Comments on the Applicant's D1 Submissions

This document sets out the comments by Cambridgeshire County Council (**CCC**) on the Applicant's Deadline 1 (**D1**) submissions. The table below provides the relevant paragraph or other references used in the submissions.

APFP Reference
Regulation 5(2)(a)

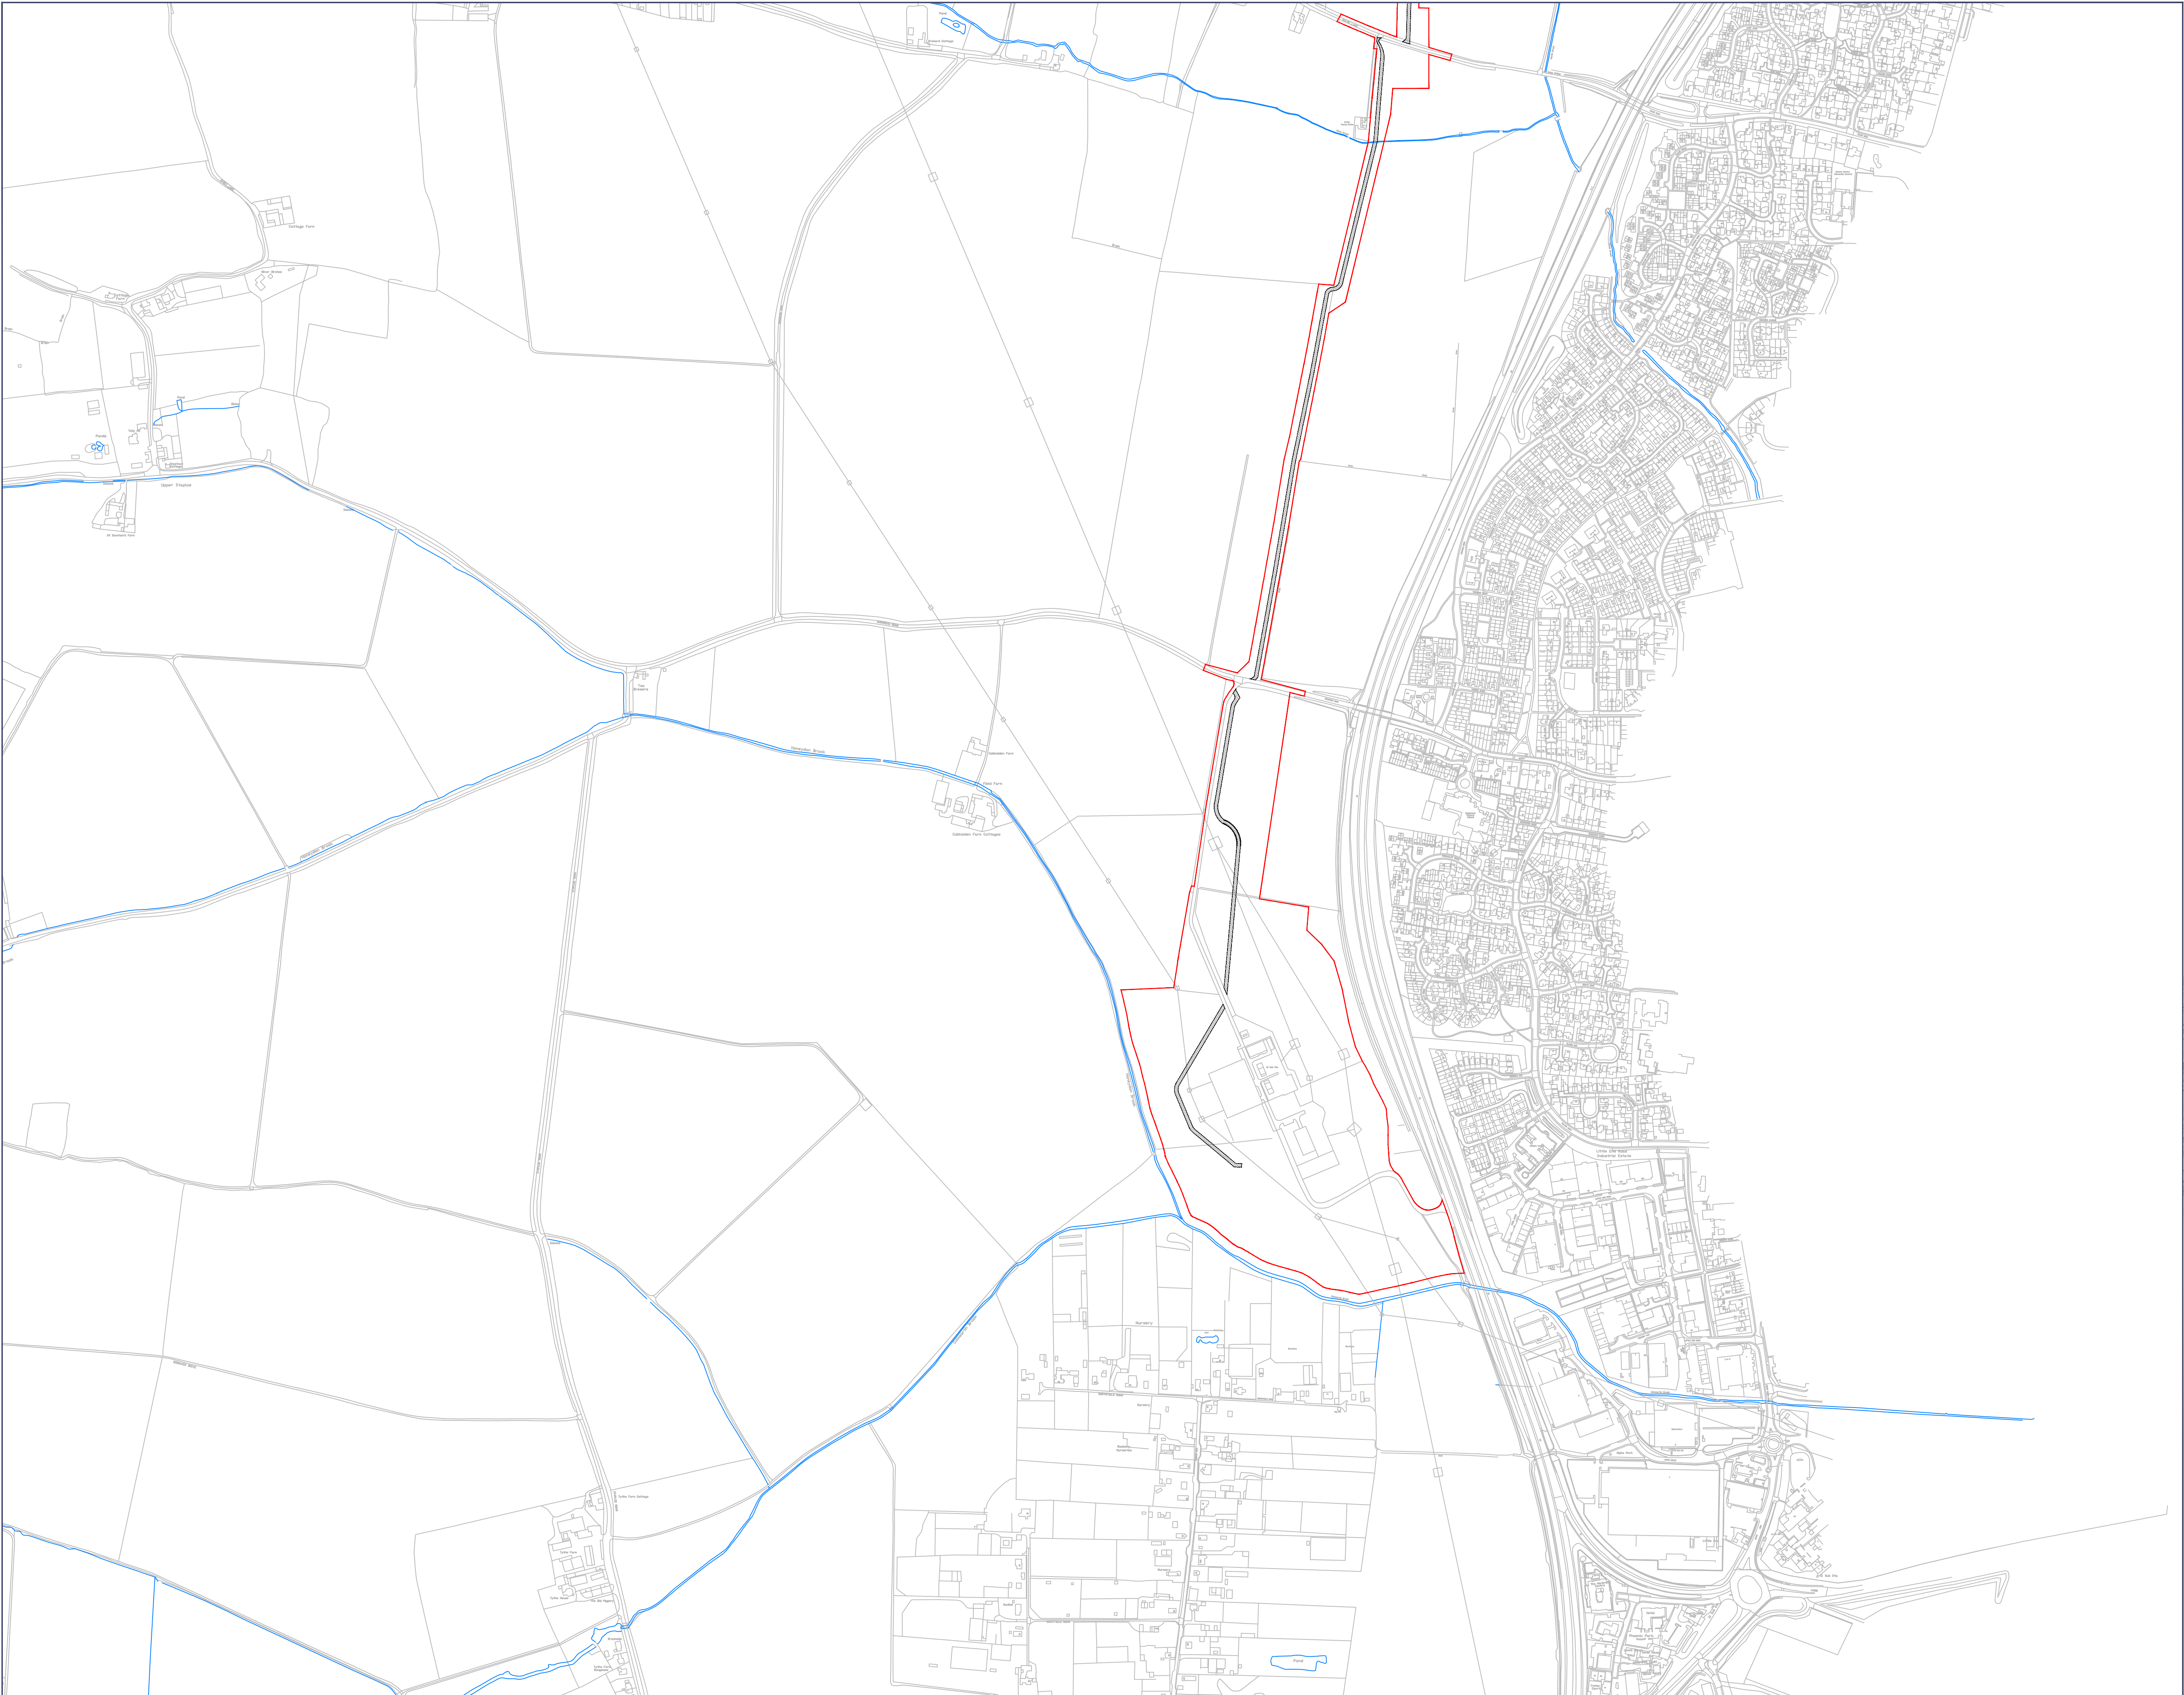
7.1.1	Each access should have a non-granular surface for a reasonable distance from the road edge where, if required, cleaning stations may be located.
Access drawing comments.	SA14 and SA15 Construction only accesses / crossing point	Visibility requirement has not been met as indicated before, the recorded speeds are above those required to assess by Manual for Streets requirements i.e. above 37mph. It is noted, however, that the speed surveys were carried out remote from the location of this crossing. Therefore, either further speed surveys will be required, or temporary traffic regulation orders would be required to reduce the speeds of vehicles with appropriate warning signage.

With regards to the access width, it is noted that two vehicles are unable to pass at the location of the crossing with a 4m width. The crossing should be of sufficient width to allow two-way simultaneous movements at locations adjacent to the highway. While it is indicated within the CTMP that vehicles will be controlled so that none should meet, this safeguard should be built in as standard to mitigate for such instances.

A width of 7.3m for a distance of 20m from the road edge should be sufficient.

<p>The council queries why 4m radii have been applied to the design. As no vehicles are proposed to use Moore Road, the inclusion of these would only seem to allow manoeuvres. The council requests that the applicant removes these to ensure straight across movements only. Moore Road has limited width to accommodate construction traffic for the project.</p>
	<p>SA13 operational access</p>	<p>Whilst this is an existing access, the council has not seen any information relating to the existing use and or proposed use, so requests clarity on whether there will be additional volume.</p> <p>The proposed splays are also indicated but no speed measurements have been undertaken in this location to ascertain if they are adequate.</p> <p>The tracking has been undertaken with a 10m rigid vehicle – the council requests clarity as to whether this is the largest vehicle likely to use the access, with details provided of the frequency to ensure the single width nature is acceptable.</p> <p>The council also notes that it is not a balanced junction regarding radii, and requests further information as to whether any vehicles using the access will only enter and leave from the North.</p>

<p>SA16 Main construction access</p>	<p>In the tracking plan provided, the vehicles appear to clash when manoeuvring in the location below. The council requests that the applicant provides tracking or alters the geometry so that this does not occur.</p> 
	<p>SA12 Zantra access</p>	<p>The council notes that this access has already got approval for HGV use and there is no damage evident on Google Earth.</p>
